RE: Planning Application Number 2019/62/90988/W. Proposed Campsite development by SB Homes Ltd at land adjacent to Lock 38, Marsden, HD7 6AF

I would like to formally object to the above named amended management plan and site map as I do not consider that it fully addresses the concerns of the Consultees, myself or the other Objectors.

PROPOSED CAMPING SITE
AT LAND ADJACENT LOCK 38, OFF MARSDEN LANE,
MARSDEN HD7 6AF FOR S.B. HOMES LTD
PROPOSED SITE PLAN ~ SCALE 1:200 (A1)

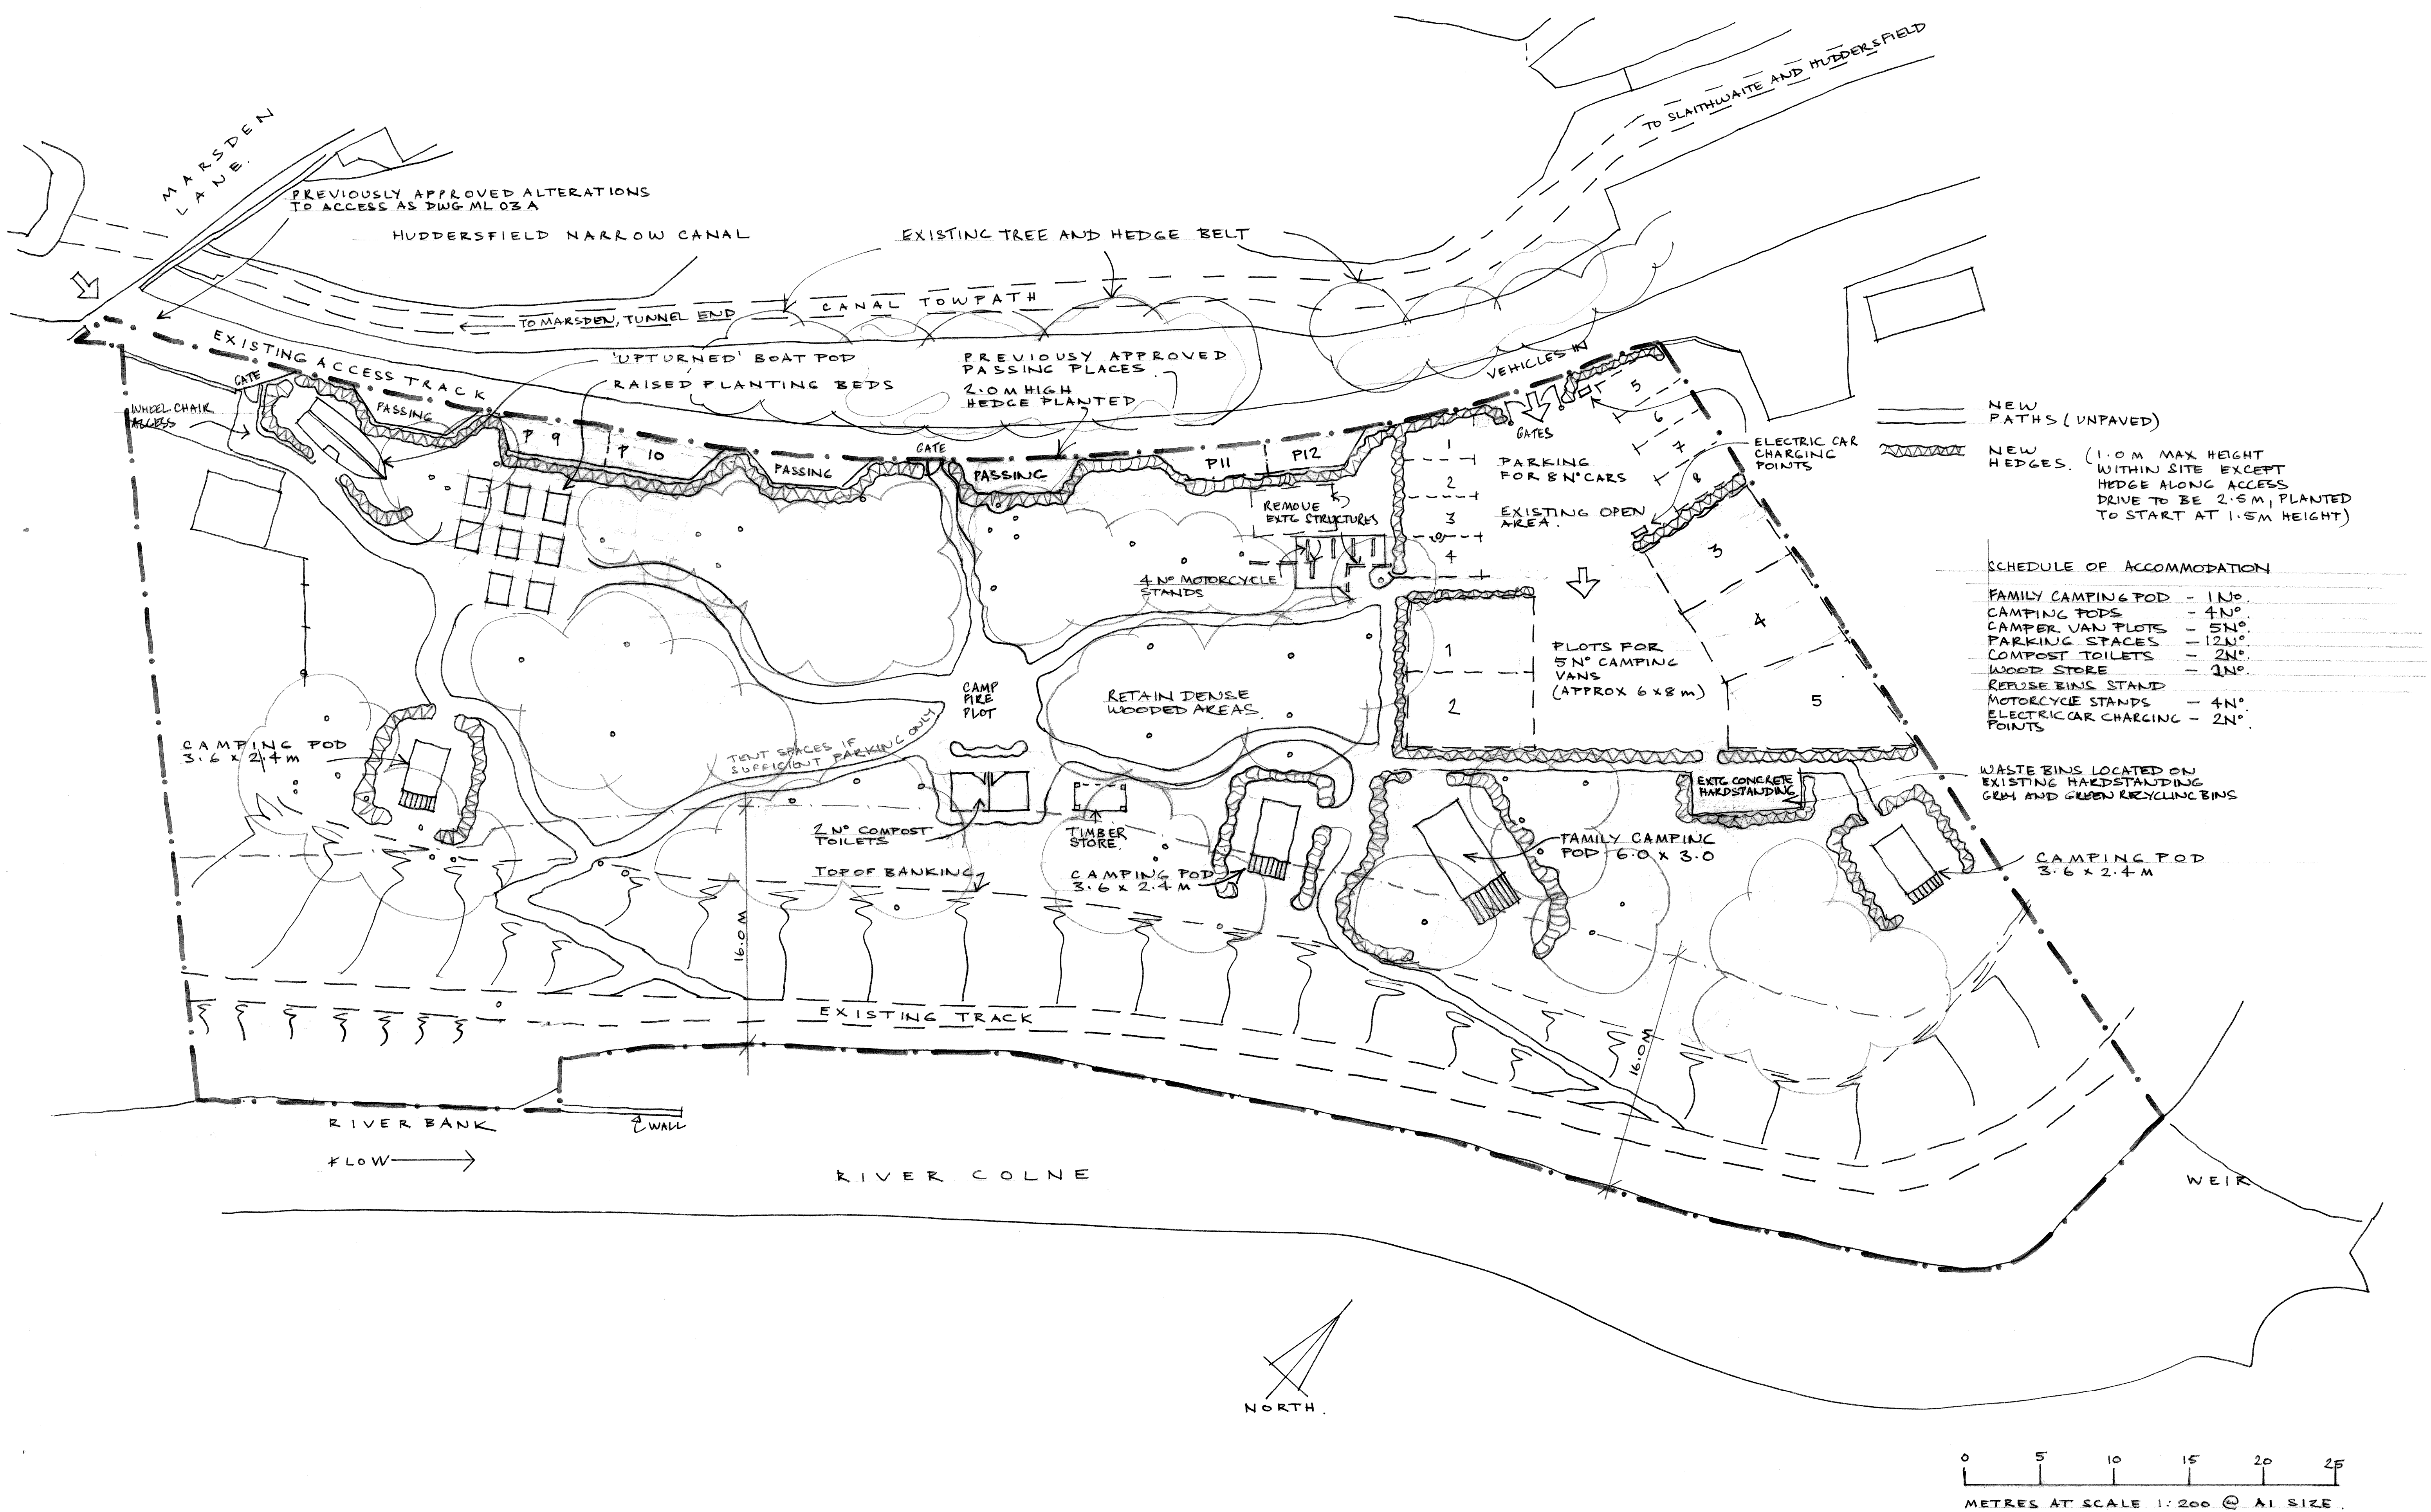
With regard to the hedge/fence that I mentioned in my previous objection letter which I believe should be installed at the southern end of the campsite or now around the new tenting area etc. This has still not been addressed. some form of privacy .

As the Campsite provider says most people will arrive by either foot or on a bicycle (or be dropped off by parents for Bushcraft) this means by default the tent spaces will always be in use. As the position of the tenting area has been moved to the left hand mid section of the Camp we please have a noise/impact reassessment on what this will mean to residents at the Southern, Northern, Western or Eastern end of the campsite or anyone else who may be affected. Also a definitive idea of the amount and the maximum amount of tenting pitches there are definitely going to be and in exactly what area like there was in the previous plan.

7) Can we also have a detailed plan of where the activities are going to be held on the site as well for both the Camping and Bushcraft activities??
